## Application for a Non-Material Amendment Following a Grant of Planning Permission

22/03524/FULL6 | Demolition of two existing conservatories and erection of a two storey rear extension and a single storey rear extension and internal remodelling | 154 Chislehurst Road Orpington BR6 0DT

Move the kitchen wall by 170mm to the South in line with the original house.  
This area is a single storey extension.

**PROPOSED GROUND FLOOR PLAN**  
@ 1:100

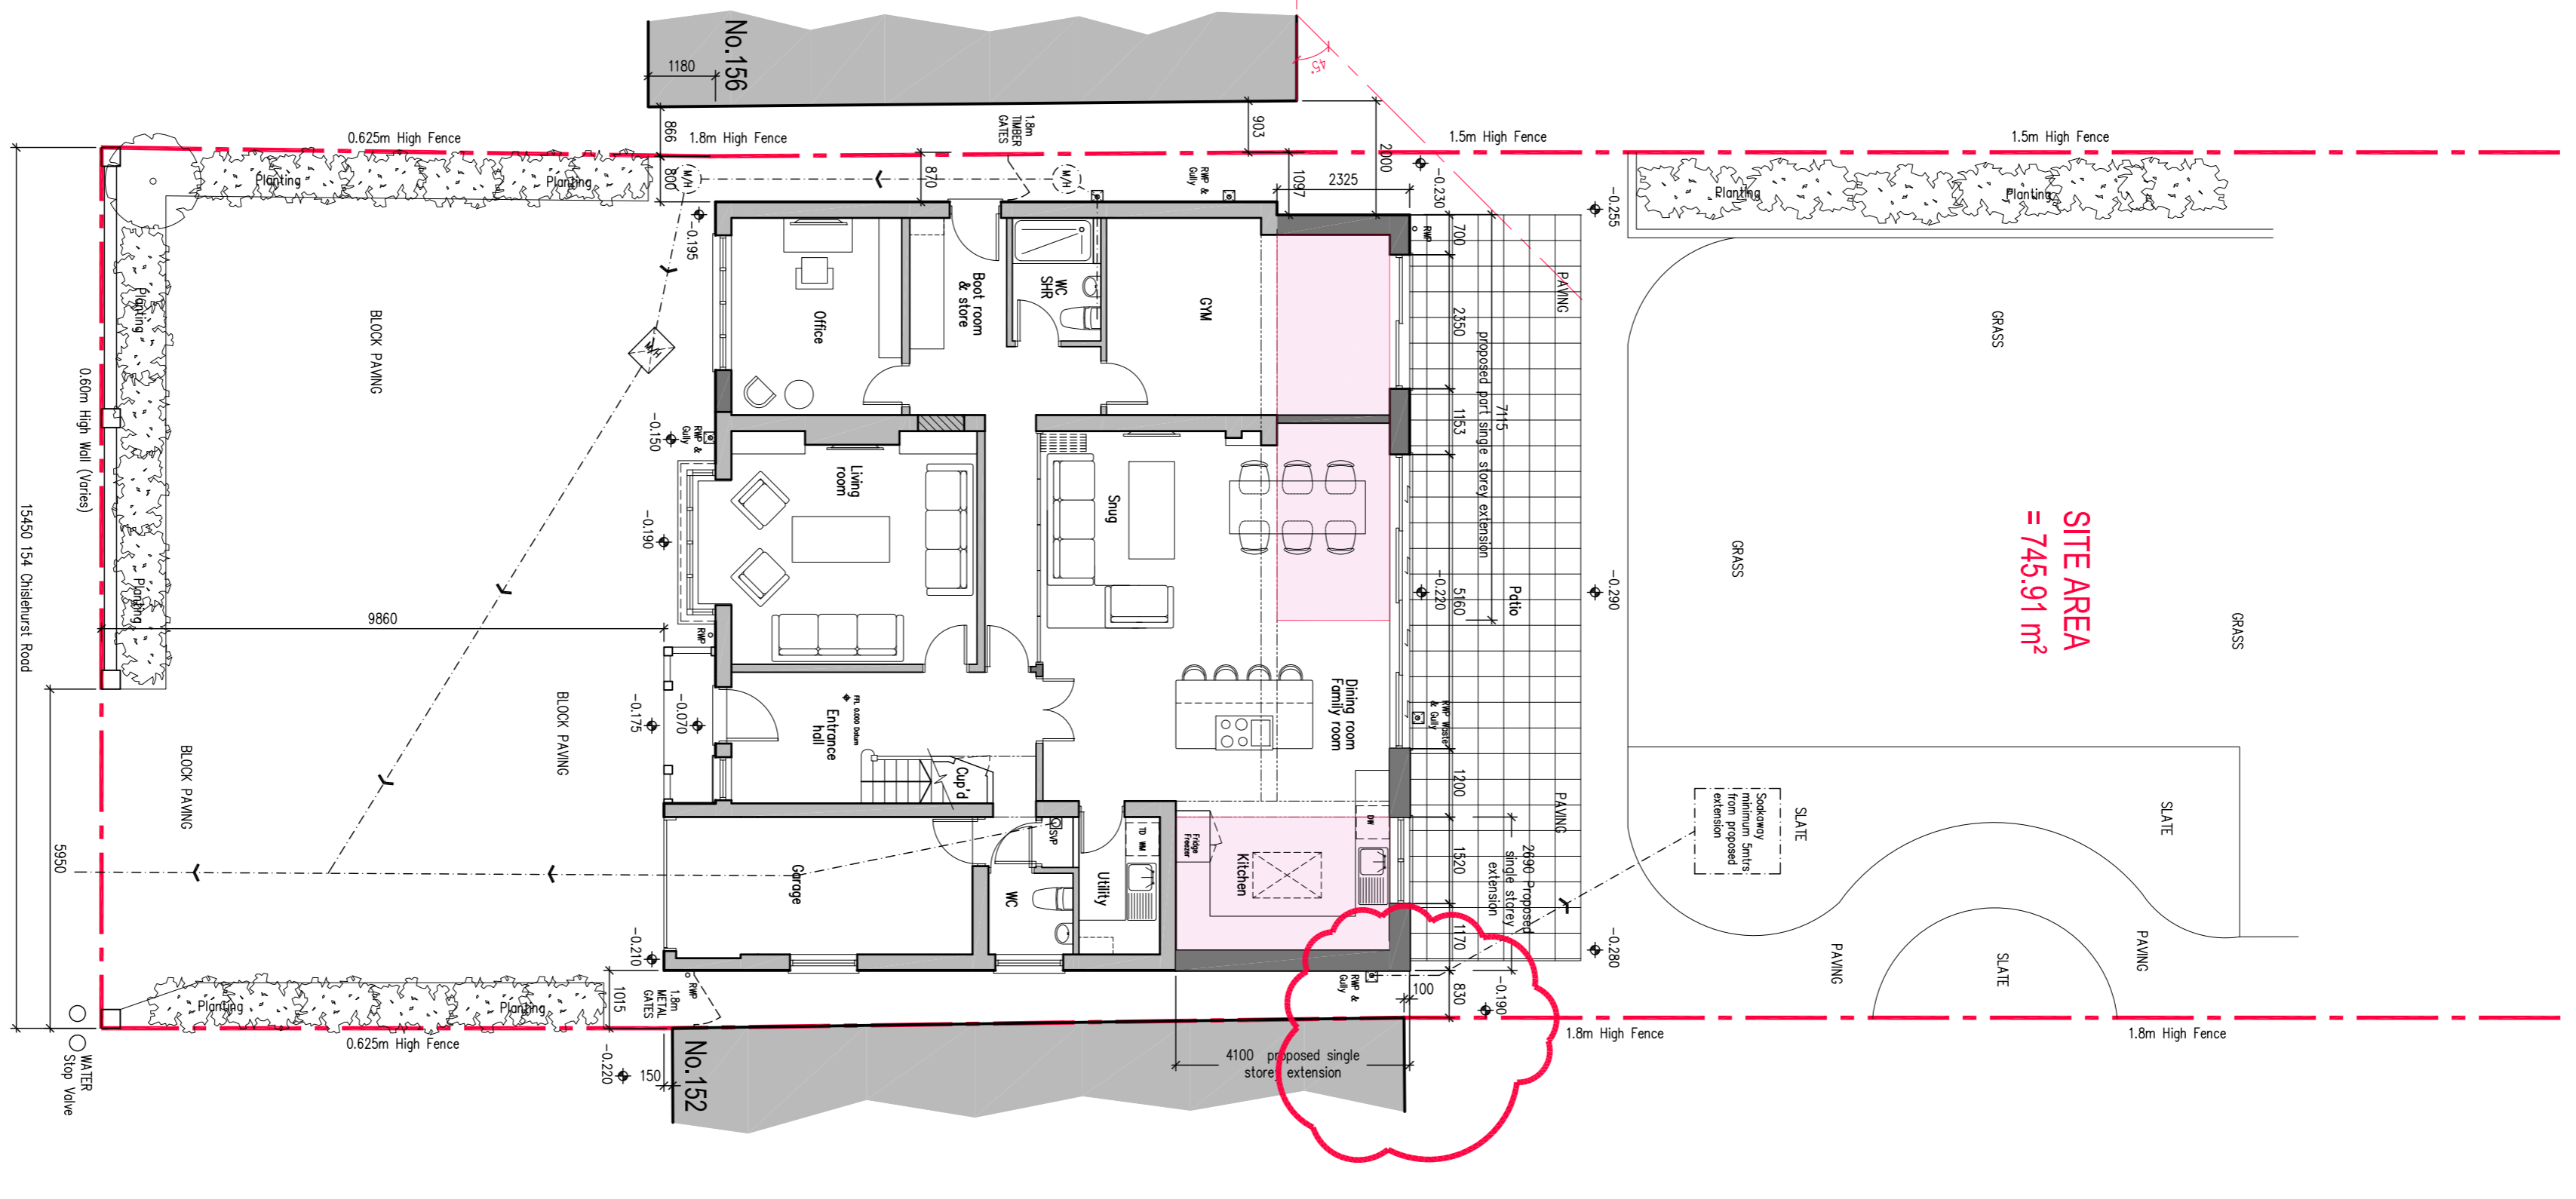
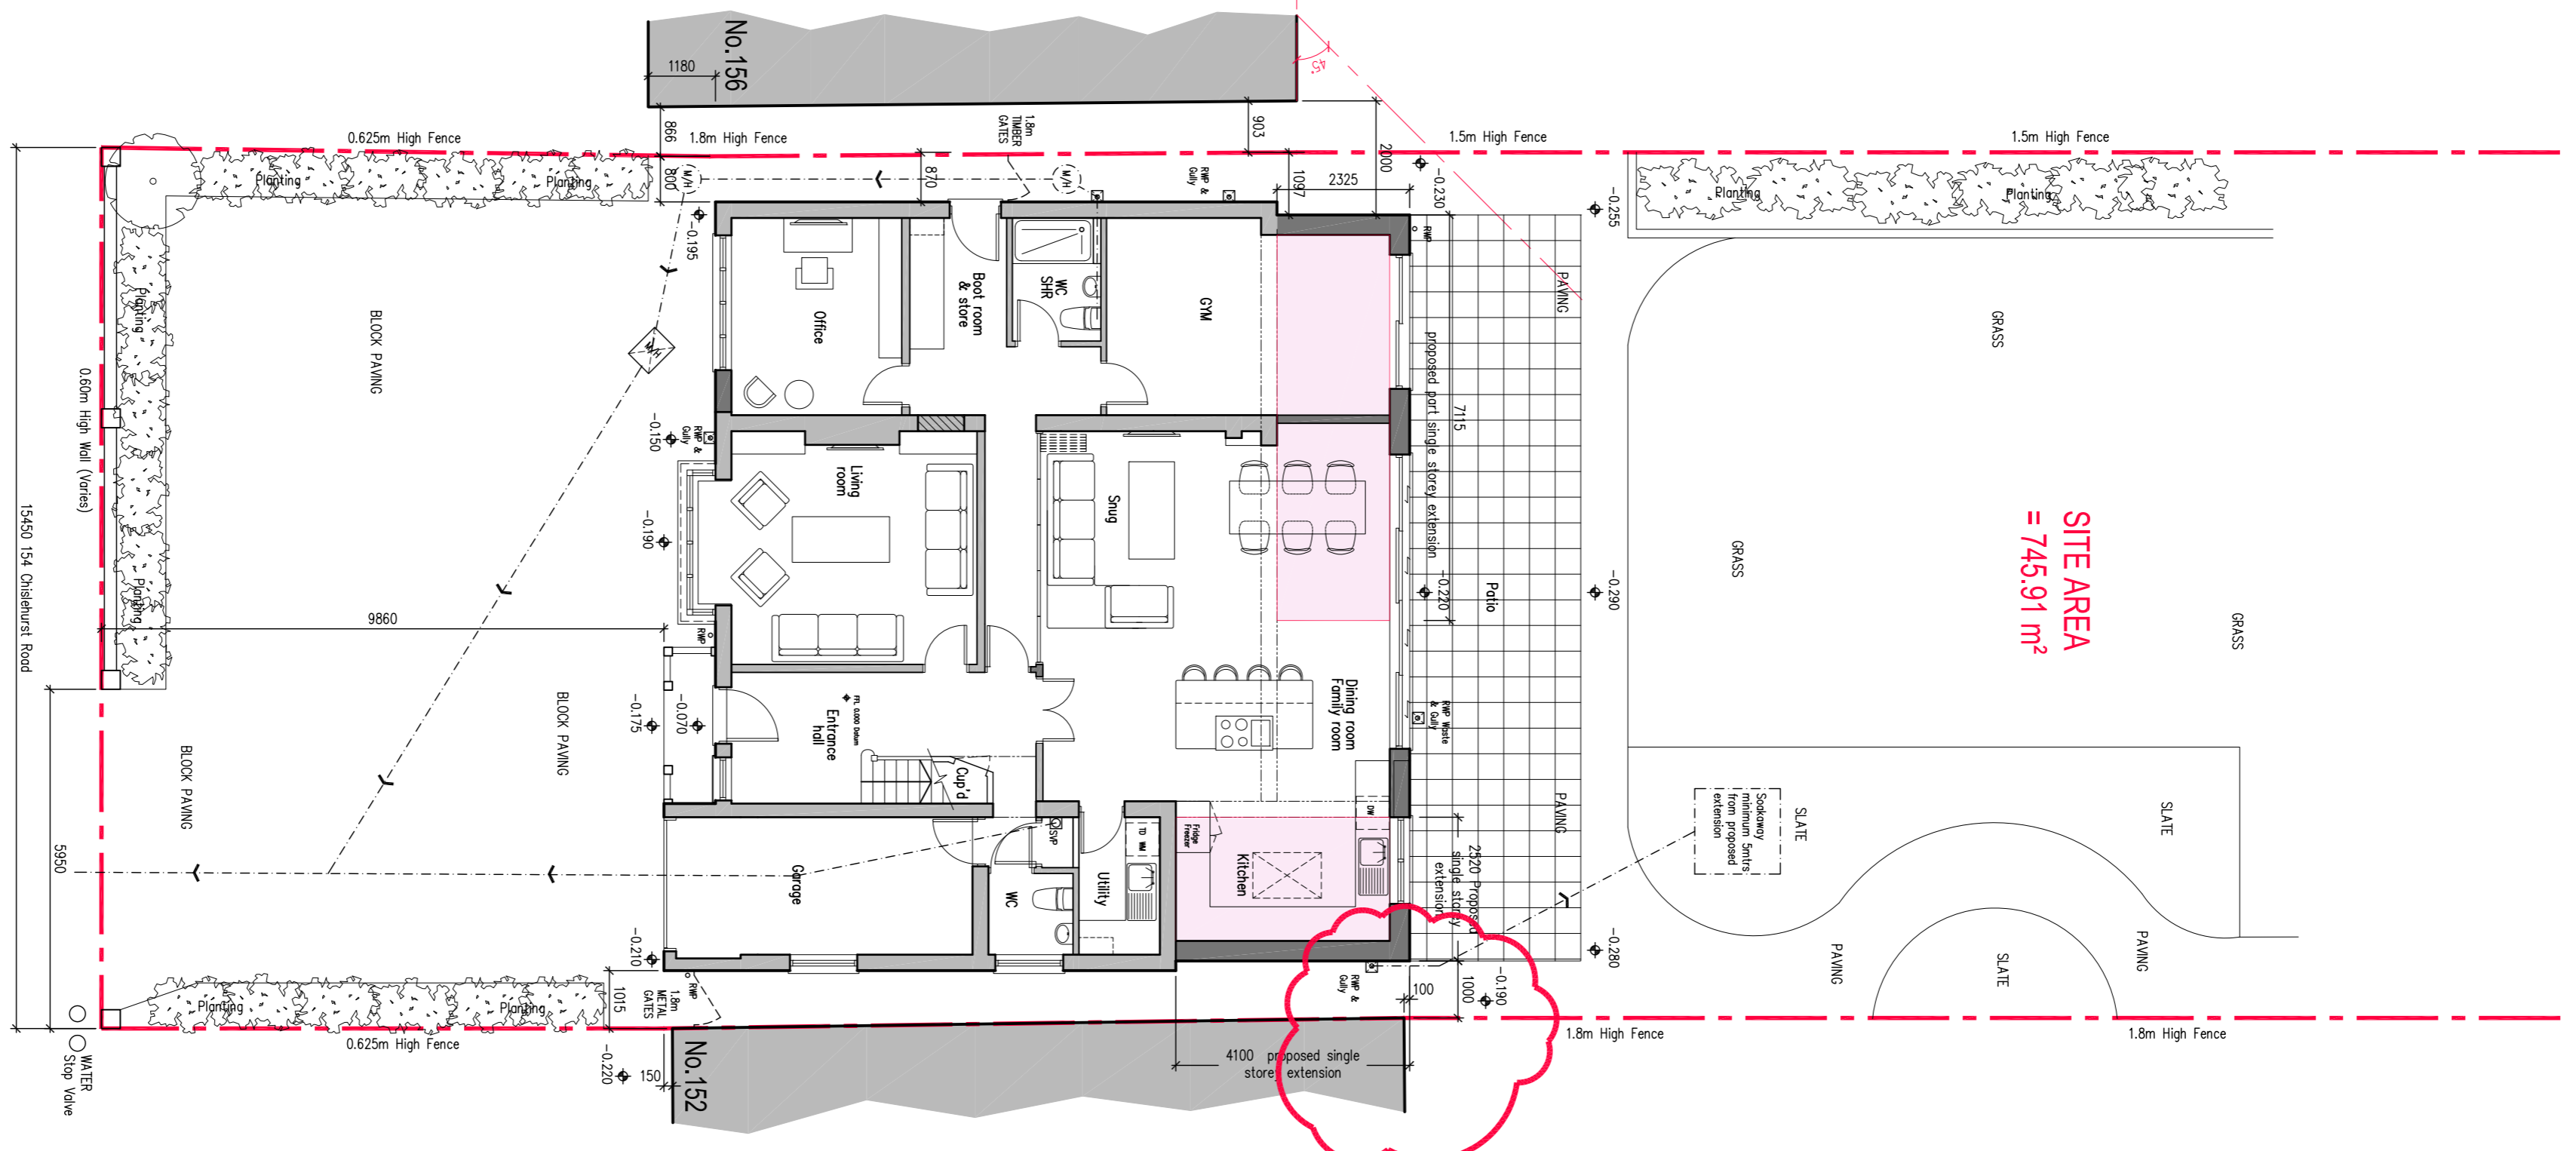
The builder has already built this single storey extension in line with the original house.

P021Rev01, P022Rev01, P023Rev01
